West Burton Solar Project

Schedule of Changes Revision C (Deadline 4)

PINS reference: EN010132
Document reference: EX4/WB8.1.8_C
The Infrastructure Planning (Examination Procedure) Rules 2010
Rule 8(1)(k)

Figure 8.18.2: Landscape and Ecology Mitigation and Enhancement Measures West Burton 2 Revision A

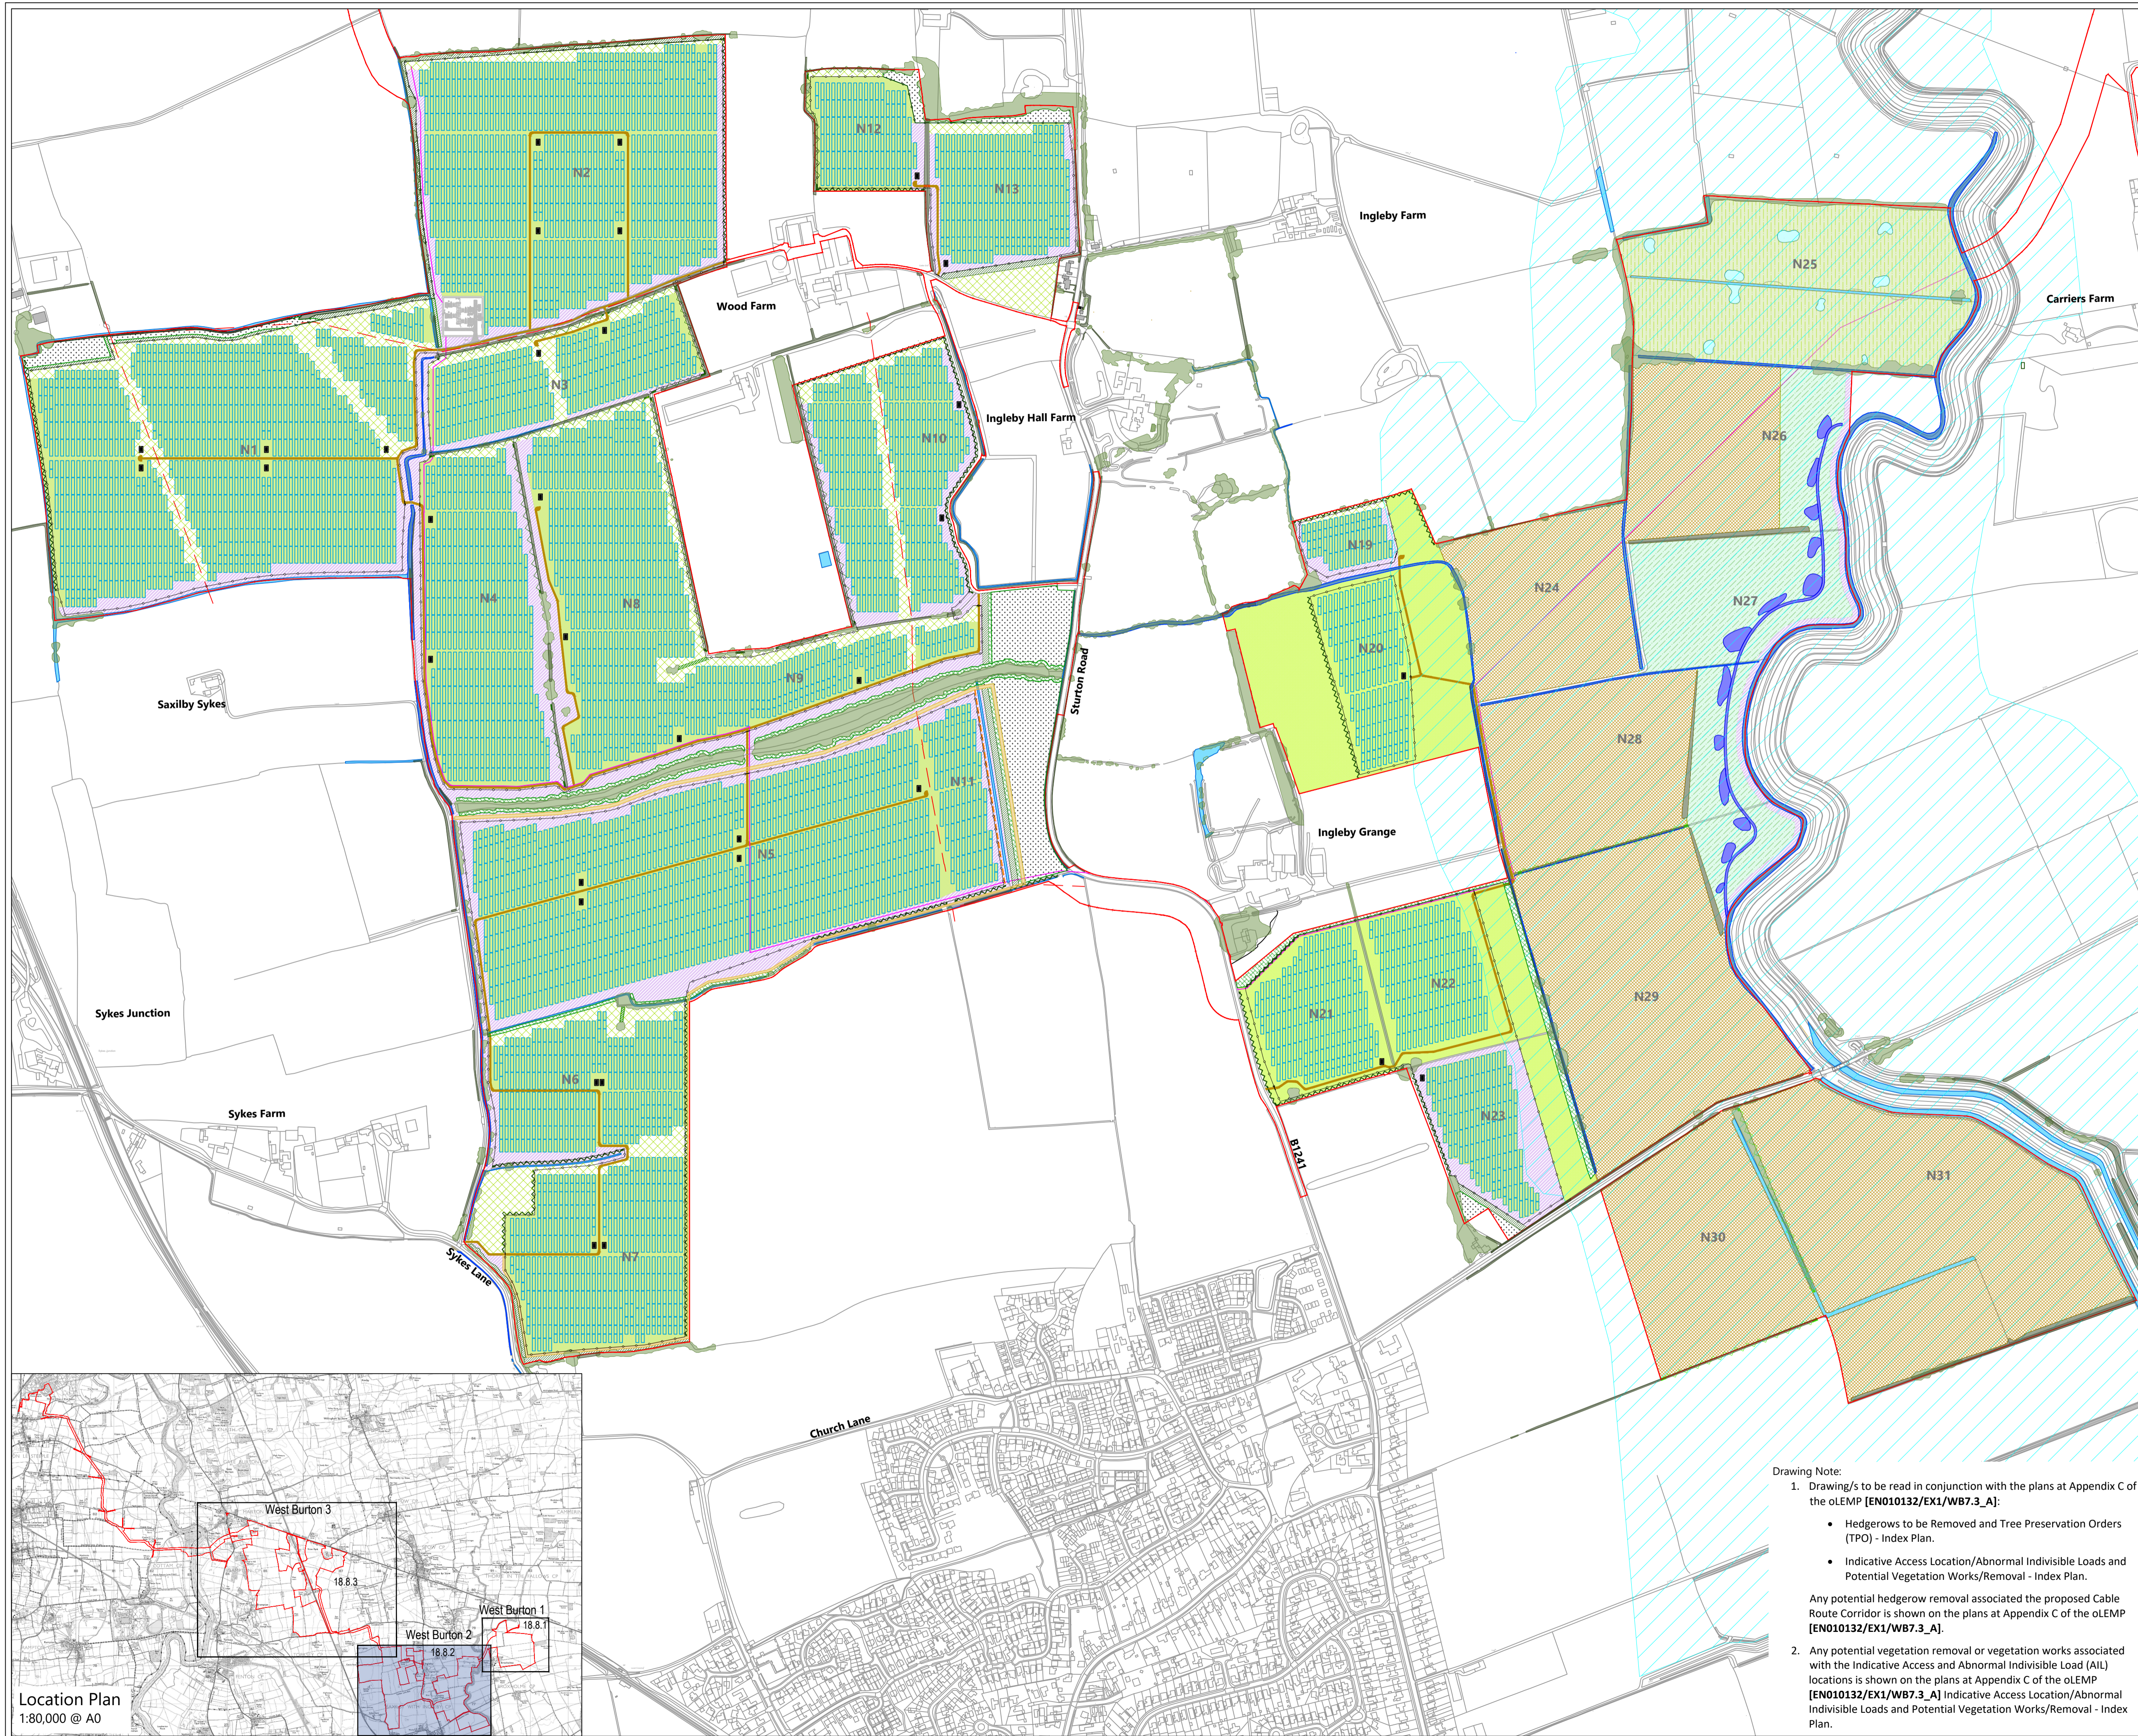
Document Name	Submitted Document Reference	Revision and New Reference	Change	Reason for Change
Measures - West Burton 1				
WB6.4.8.18.2 ES Figure 8.18.2 - Landscape and Ecology Mitigation and Enhancement Measures - West Burton 2	[APP-282]	Revision A [EX1/WB6.4.8.18.2_A]	Correction of typos, to show additional hedgerows to be removed and to provide clarity of IDB Drain locations.	Minor editorial changes for clarity.
WB6.4.8.18.3 ES Figure 8.18.3 - Landscape and Ecology Mitigation and Enhancement Measures - West Burton 3	[APP-283]	Revision A [EX1/WB6.4.8.18.3_A]	Correction of typos, to show additional hedgerows to be removed and to provide clarity of IDB Drain locations.	Minor editorial changes for clarity.
WB6.5 Environmental Statement - Non-Technical Summary	[APP-308]	Revision A [EX1/WB6.5_A]	Paragraphs 6.3.60 to 6.3.62 corrected to show that the significant effects are adverse.	To correct typographical errors.
